Arun District Council
Arun Civic Centre
Maltravers Road
Littlehampton
West Sussex BN17 5LF
Planning & Building Control General Enquiries
Tel: (01903) 737756 Fax: (01903) 730442
Dx: 57406 Littlehampton
Minicom: 01903 732765
e-mail: planning@arun.gov.uk
website: www.arun.gov.uk/planning

Application No: R/222/21/HH
Site Address: 42 Pigeonhouse Lane Rustington BN16 2BE
Description of works: Single storey rear extension and hip to gable loft conversion with 2 x dormers following the demolition of existing rear conservatory

Thank you for your internet representation made on 14th October 2021 which has been recorded as an objection with the comments as follows:

A 04

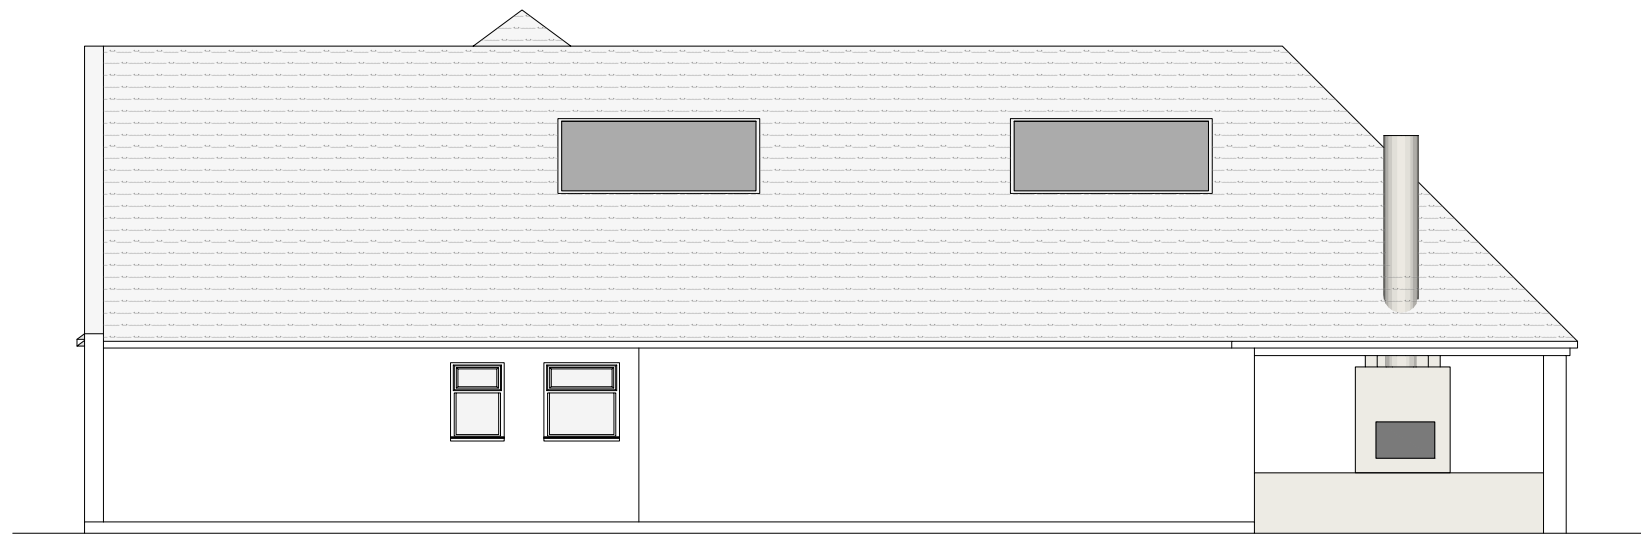
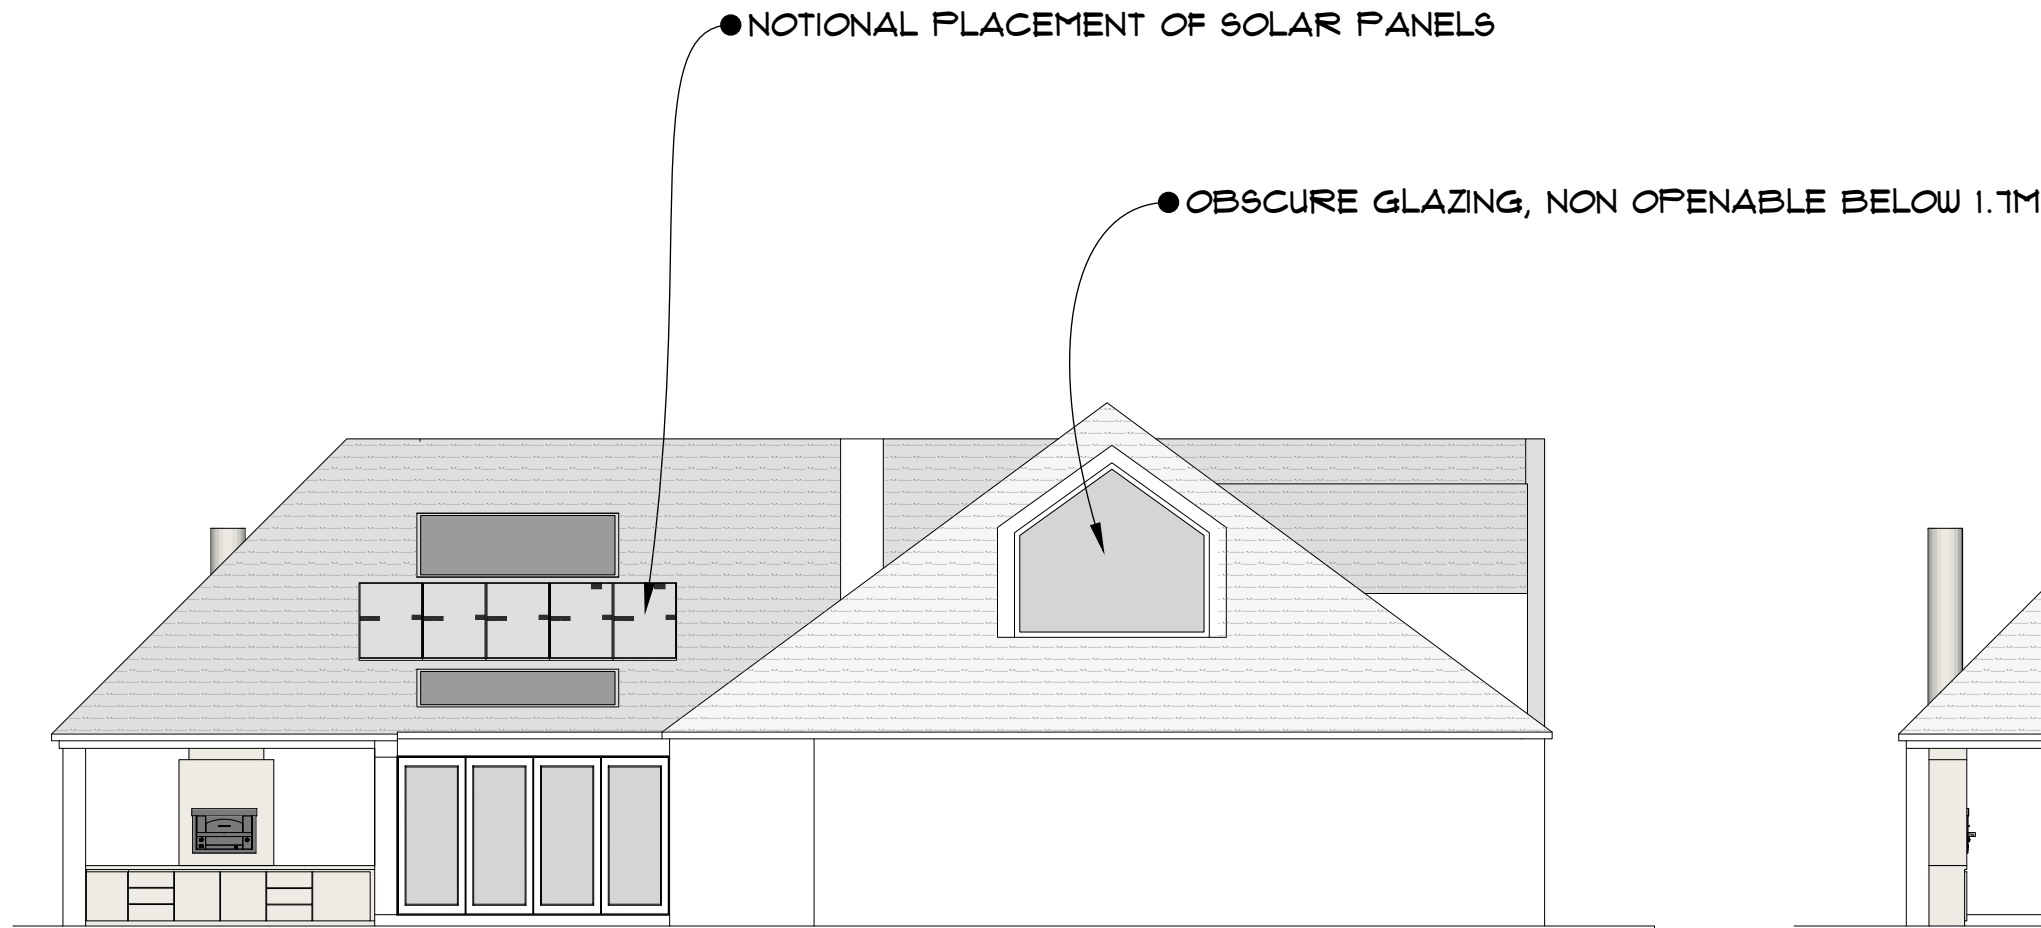
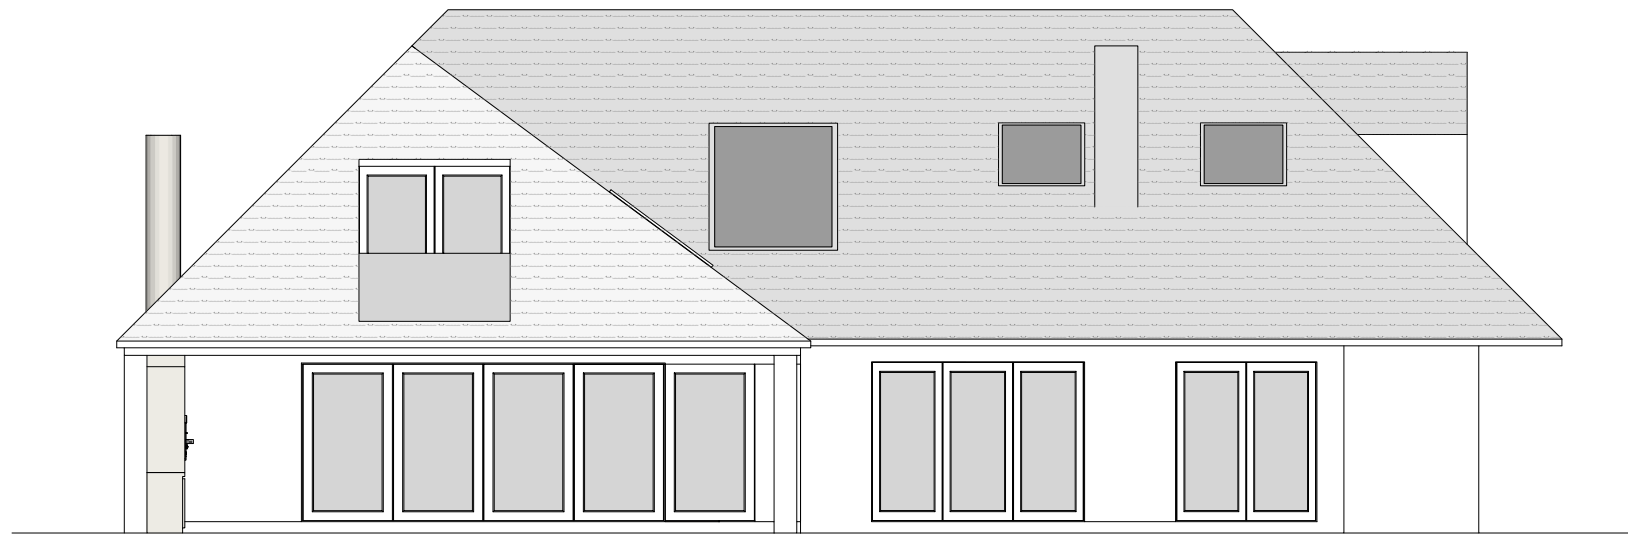
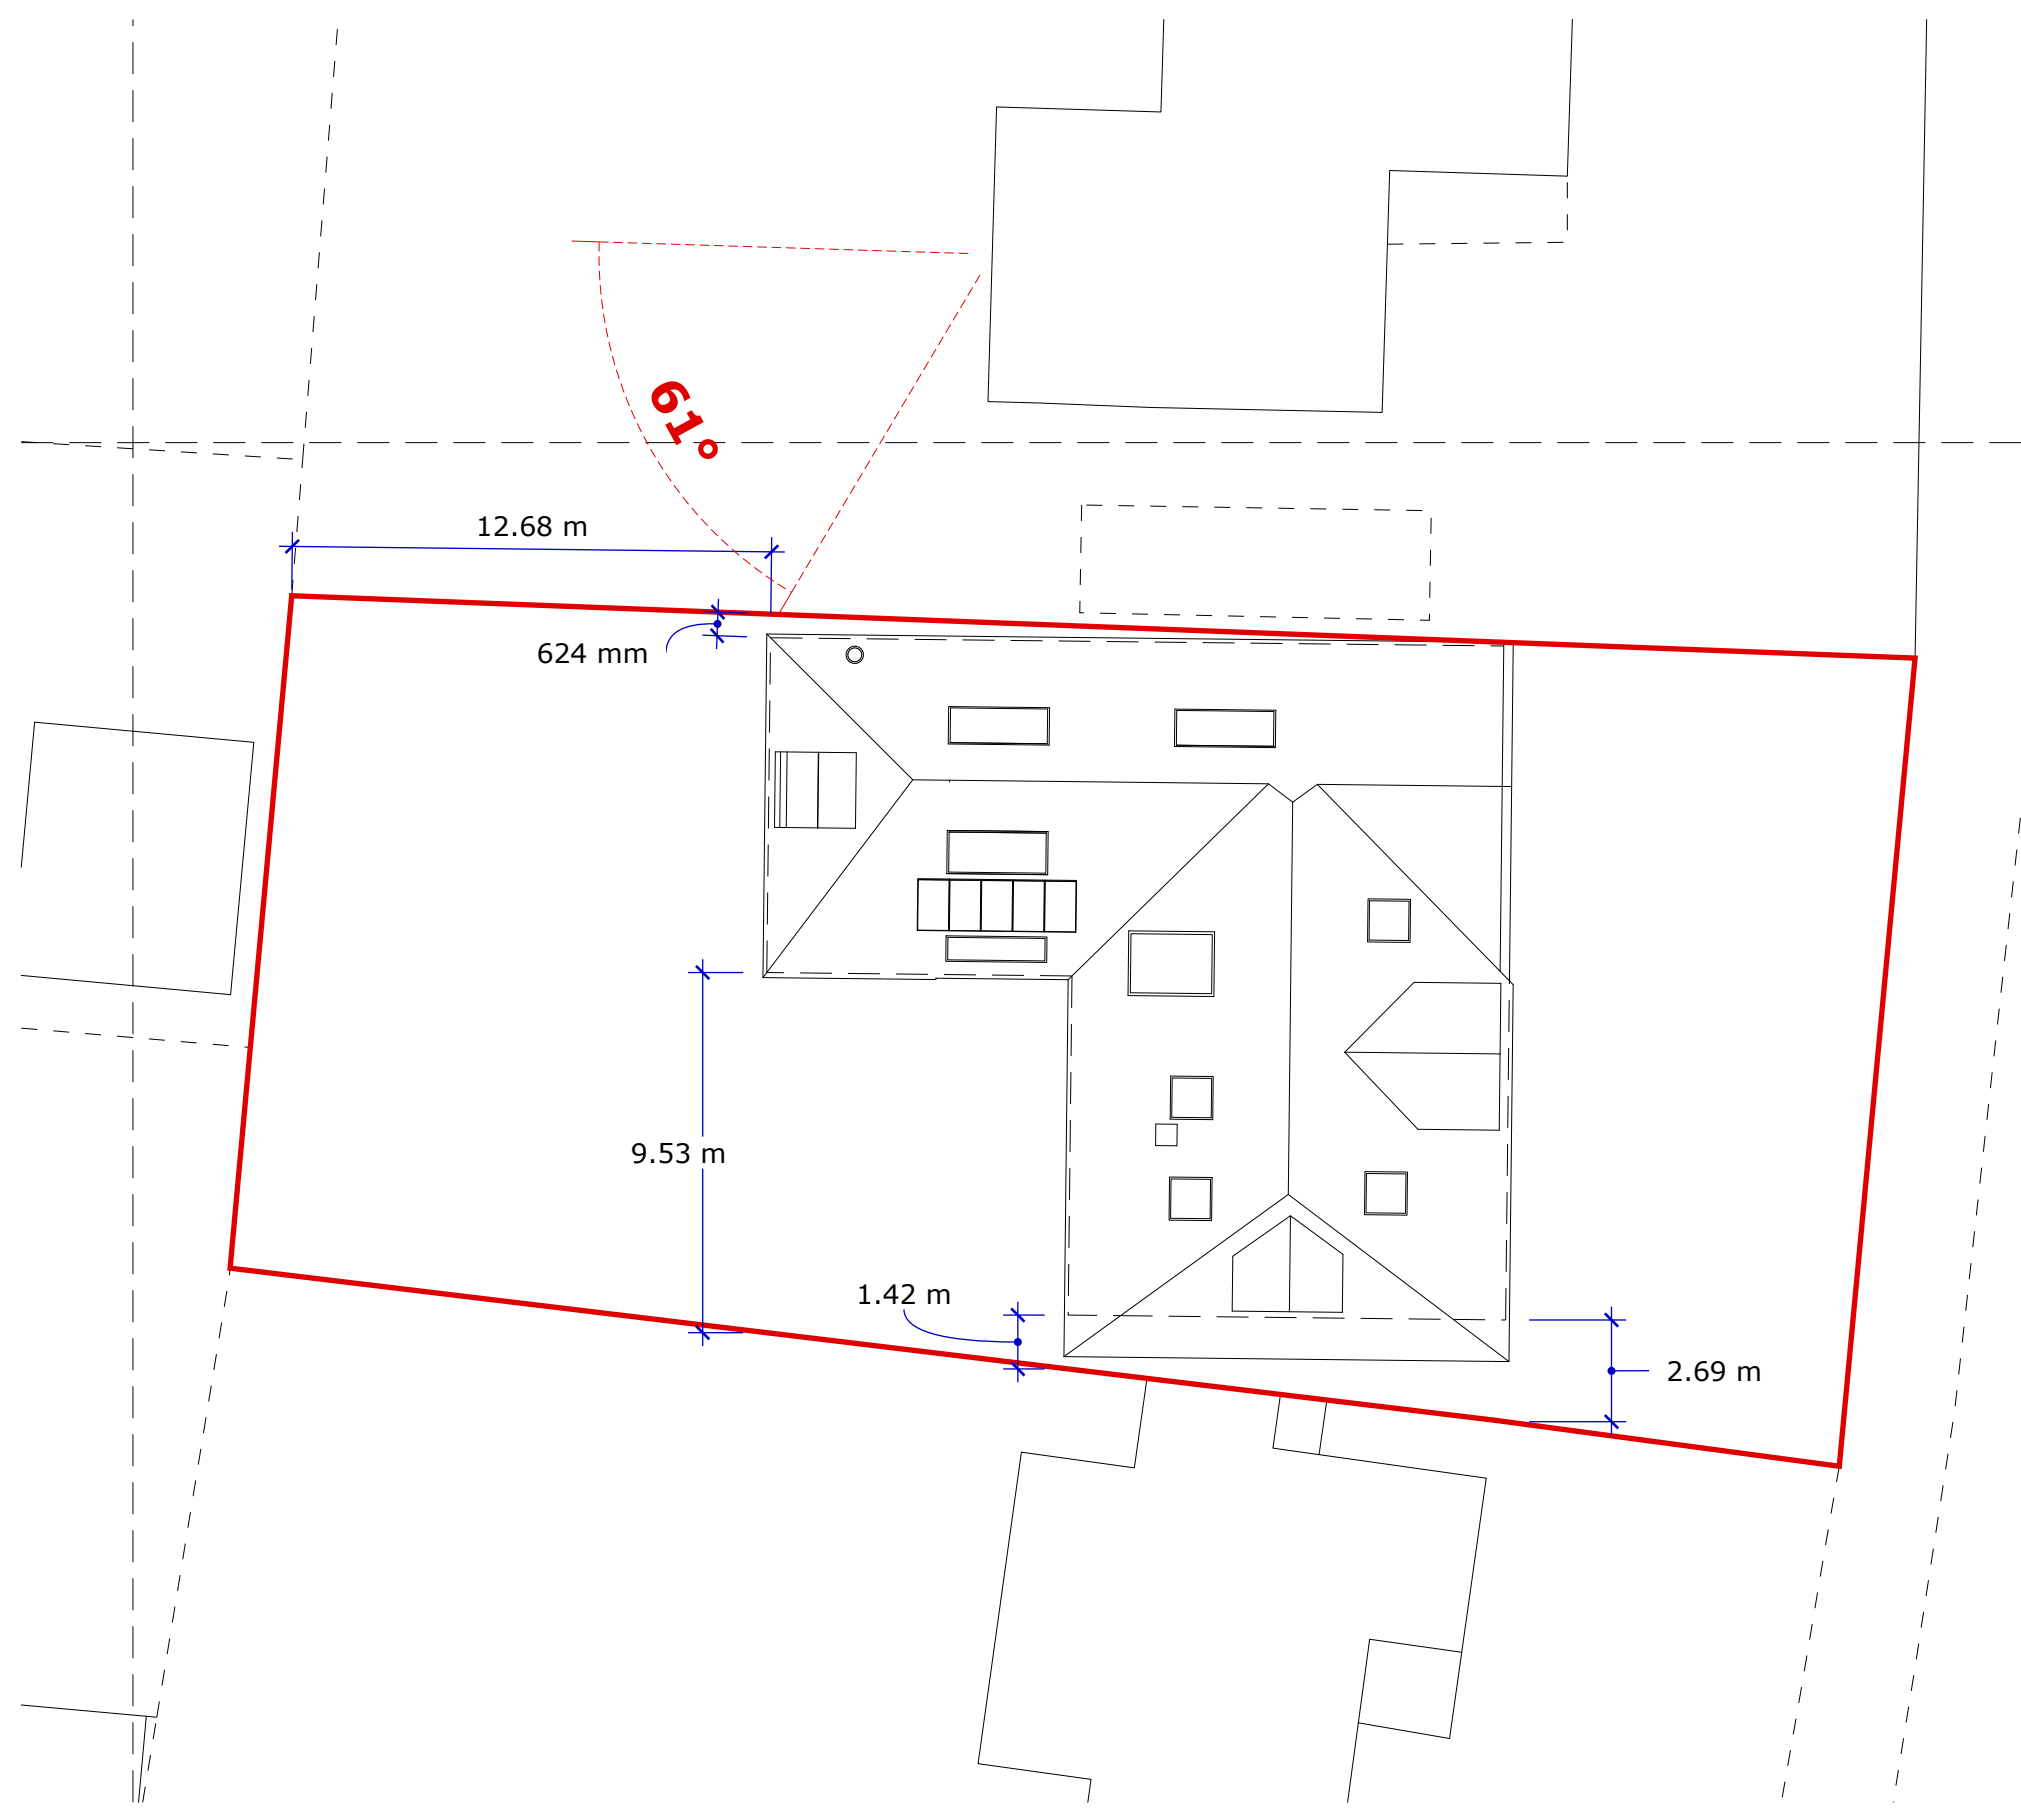
The first floor Dormer on South roof elevation when in isolation is not an issue however when taking into consideration our property to South which has a tiled gabled Dormer currently facing out to the South roof elevation of the applicants property the new Dormer would appear over bearing and disjointed. We would have no objection to a Velux style Roof Window which would in our opinion be more appropriate for a bathroom set within a pitched hipped roof and ultimately be less obtrusive.
